Re: Proposed Section 96 (1A) Modification to SSD 5237-2012 Wagga Wagga Base Hospital Phases 2 and 3

In November 2013, the above application was approved for the Wagga Wagga Health Service Redevelopment (WWHS). SSD 5237 dealt with Phases 2 and 3 of the hospital redevelopment and included:

The purpose of this letter is to outline the amendments proposed and to assess the impacts of these changes on the environment.

SECTIONS SHEET SECTION A

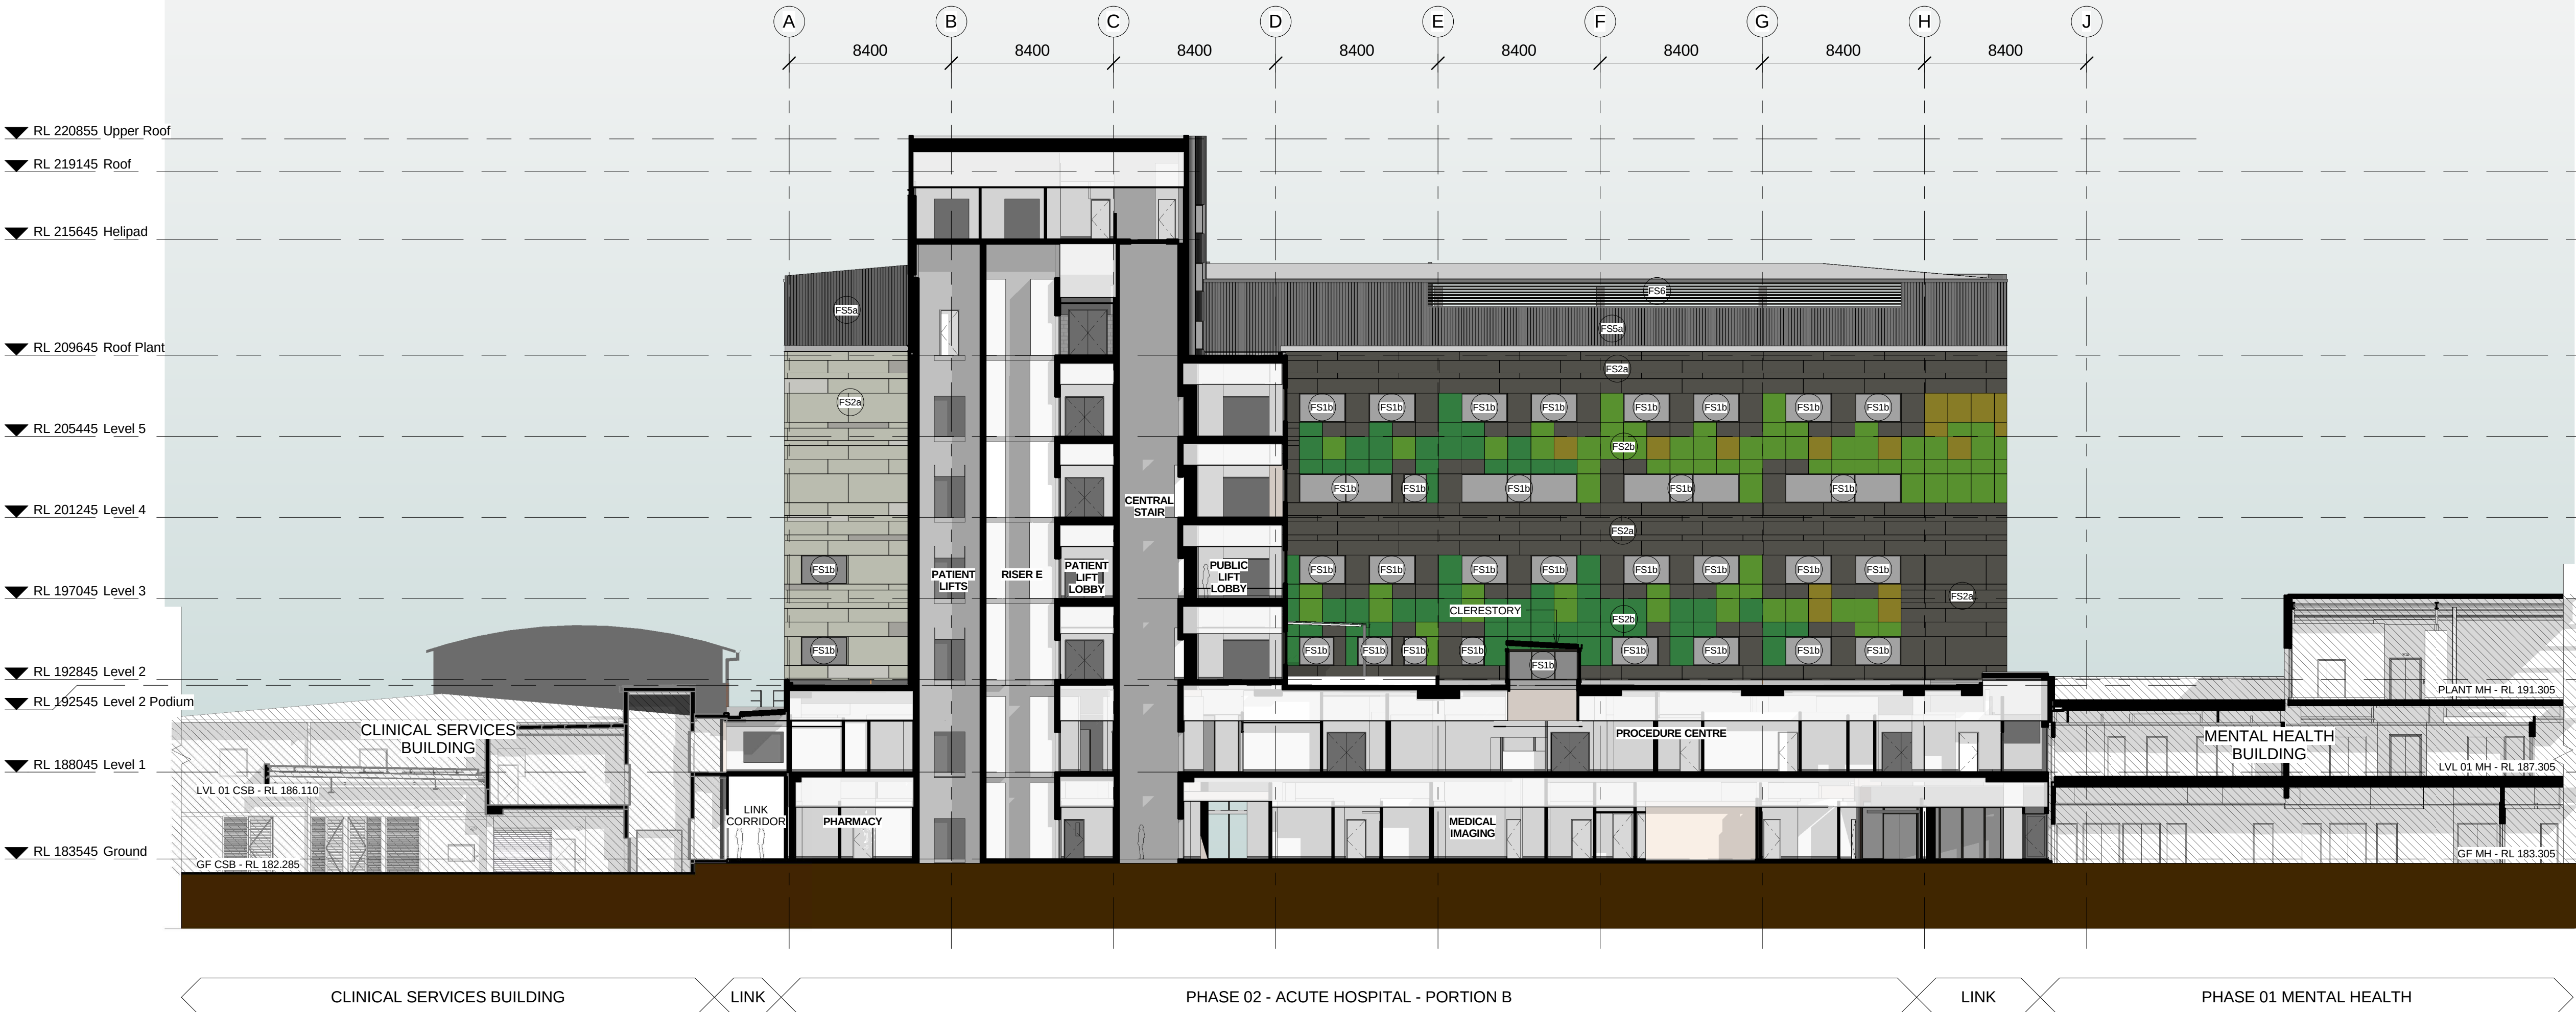
This change involves sections of the façade at level 6 that had been set back in the approved plans now being aligned with façade building envelope below. The riser located on the north side of the lift shaft has been truncated to terminate at the L.6 plant room roof and the plant room area has been reduced and the southern screen deleted.

The building floor plate has been raised by 300mm from Level 2 to maximise the freeboard interface with the Level 2 podium green roof. All floors above that have been raised as a consequence increasing the maximum height of the building by 300mm to RL 220855. An increase of 300mm to the overall height of the building is not considered to have an impact. Revised shadow diagrams have been prepared and are attached that indicate that the shadow impacts of this amendment are negligible.

ELEVATION 02 - SOUTH

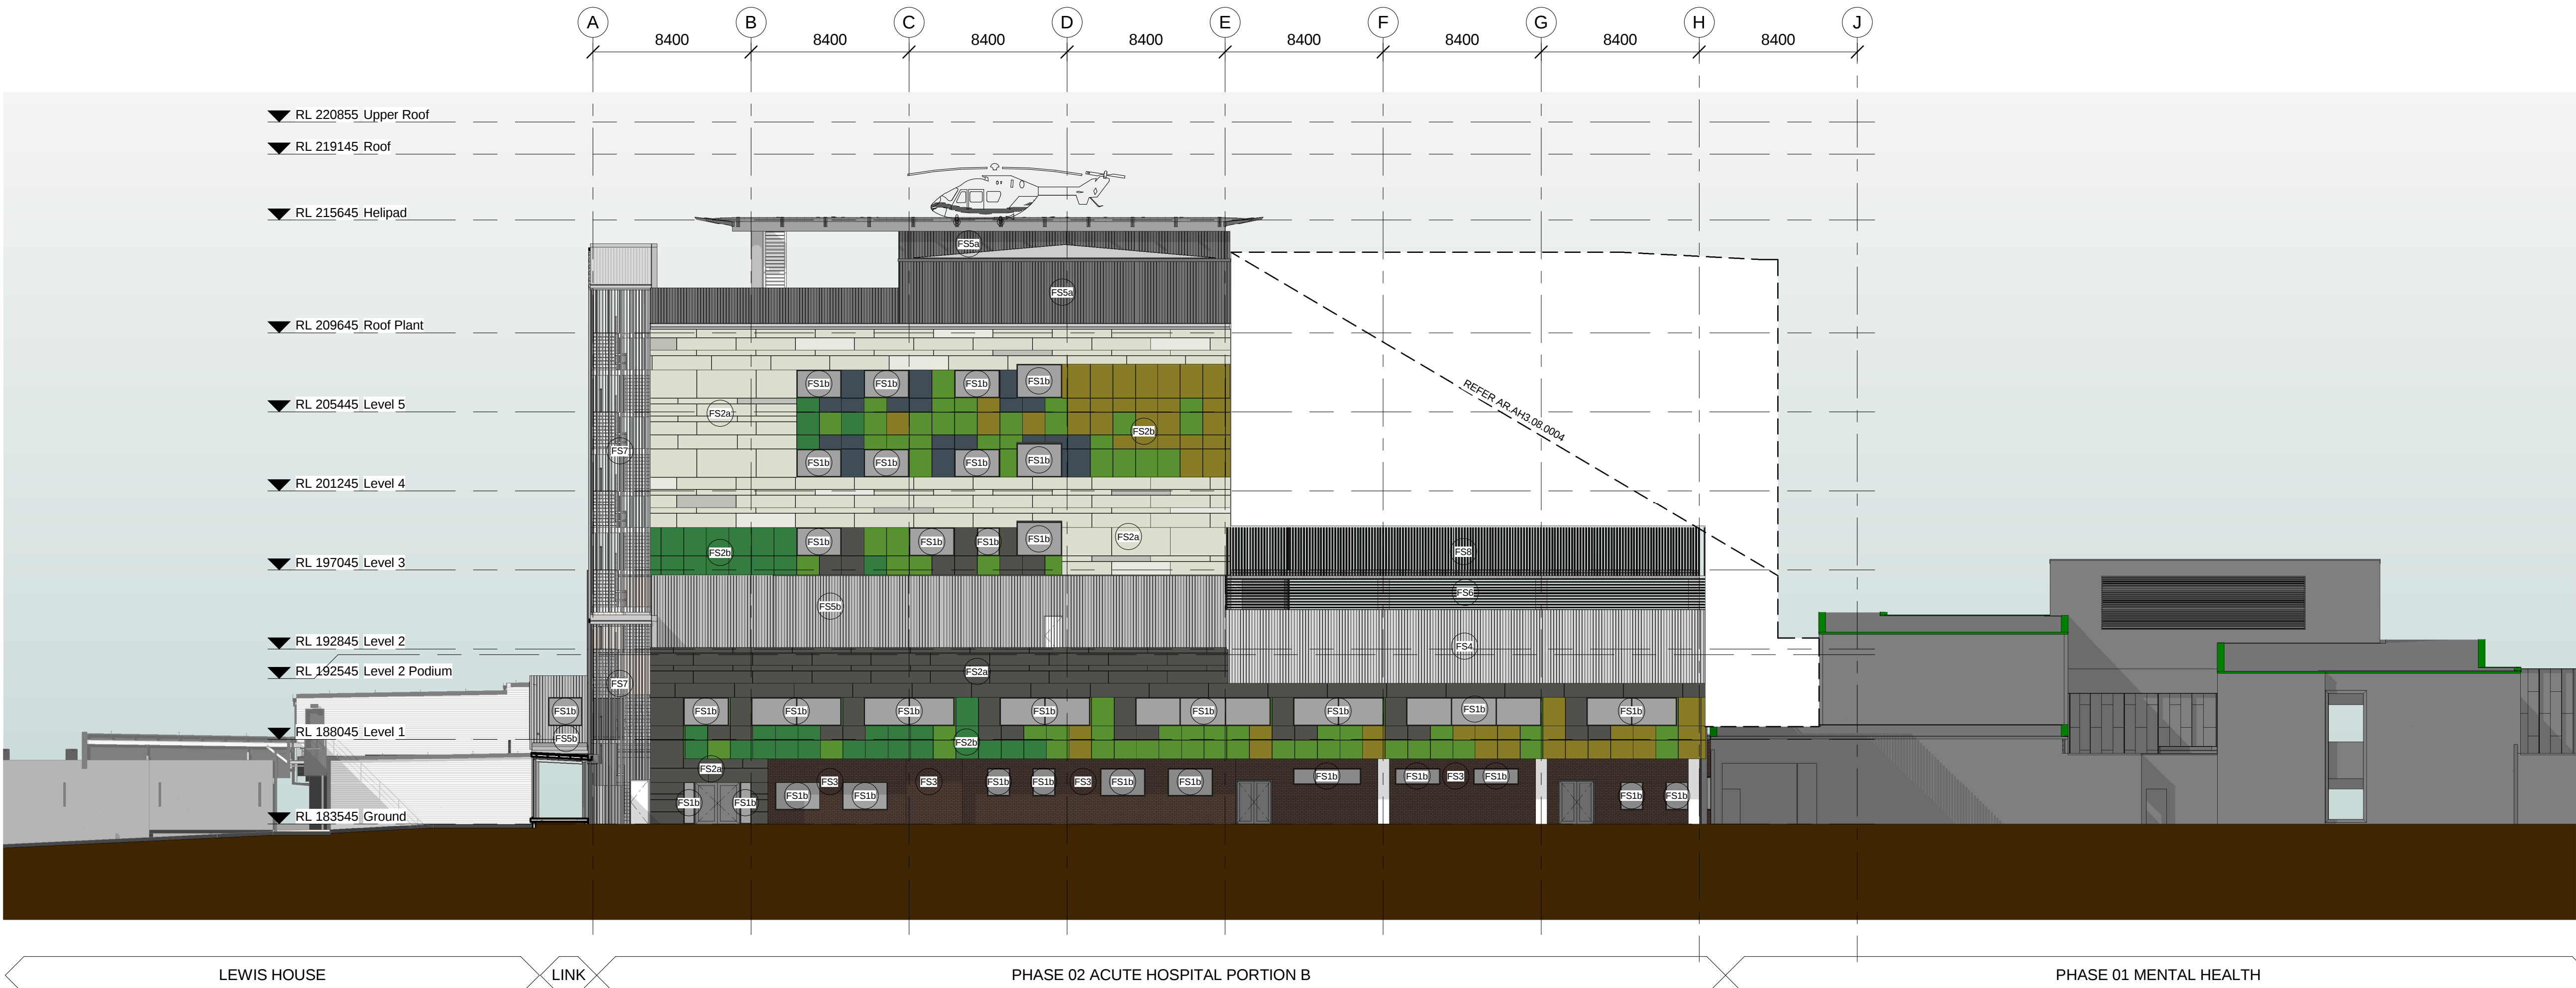
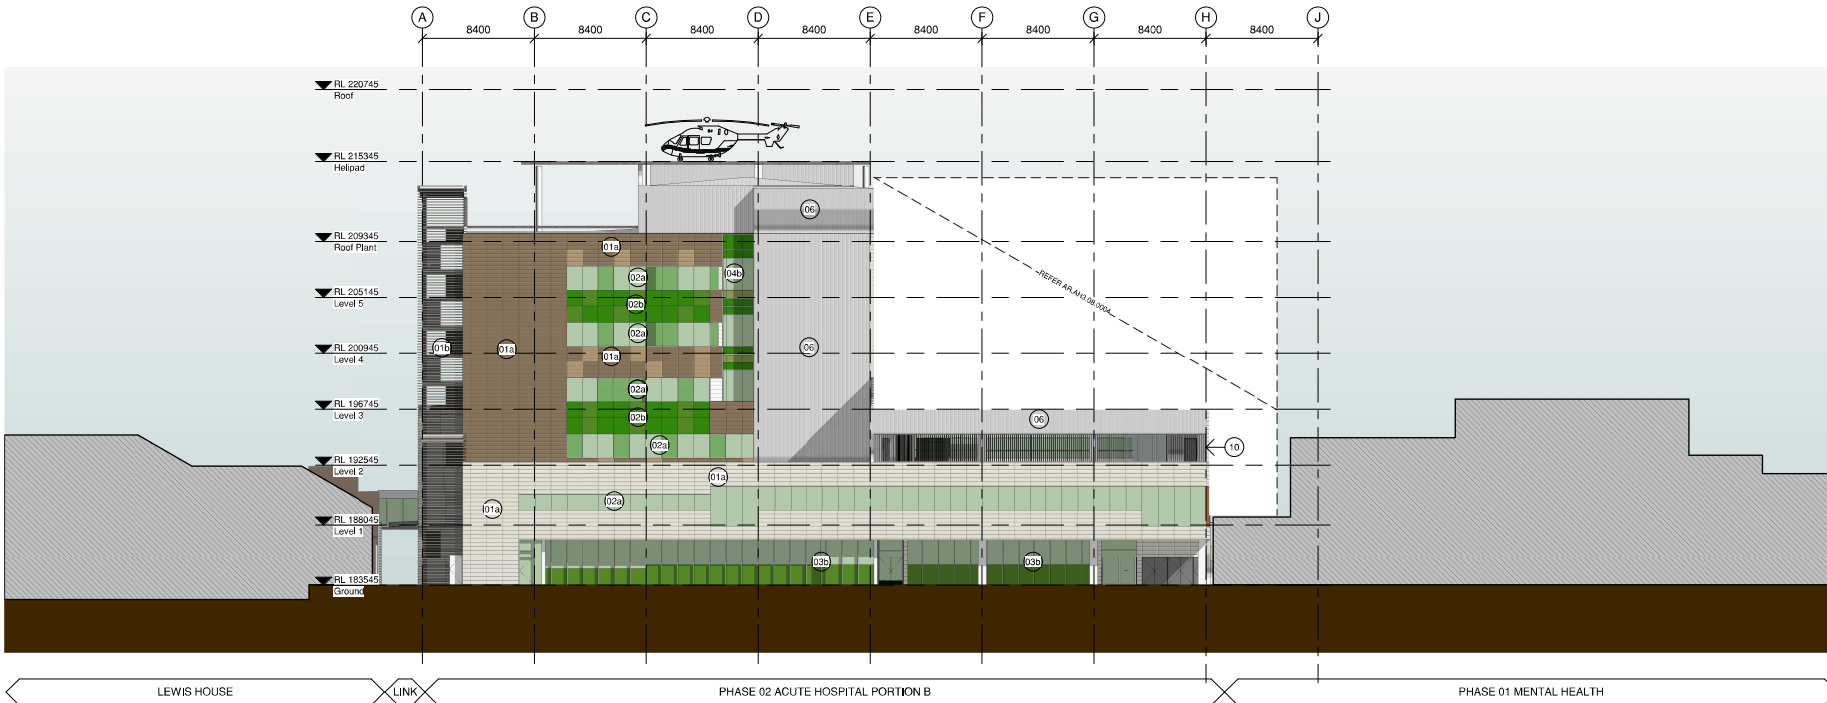
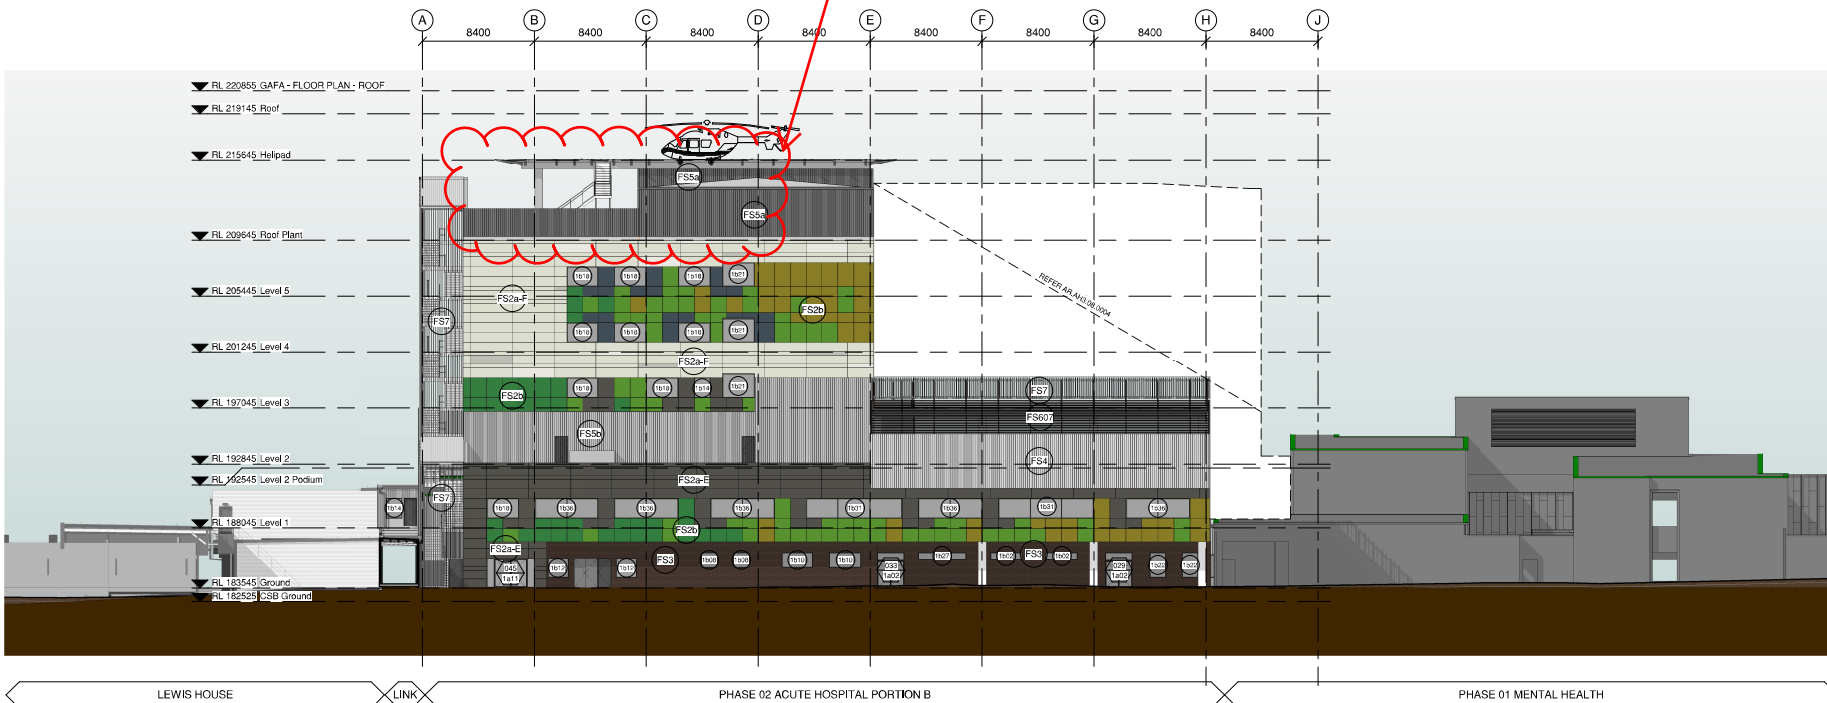
The material Terracade (ceramic tile cladding system) & anodised aluminium façade cladding has been replaced with an aluminium composite panel (ACP) system. The vertical sun shade fins have been deleted. The façade panel break has altered to suit the new cladding material. There is no change in the overall colour scheme. The details of these changes are shown on the attached drawings and comparison sheets (Attachment A).
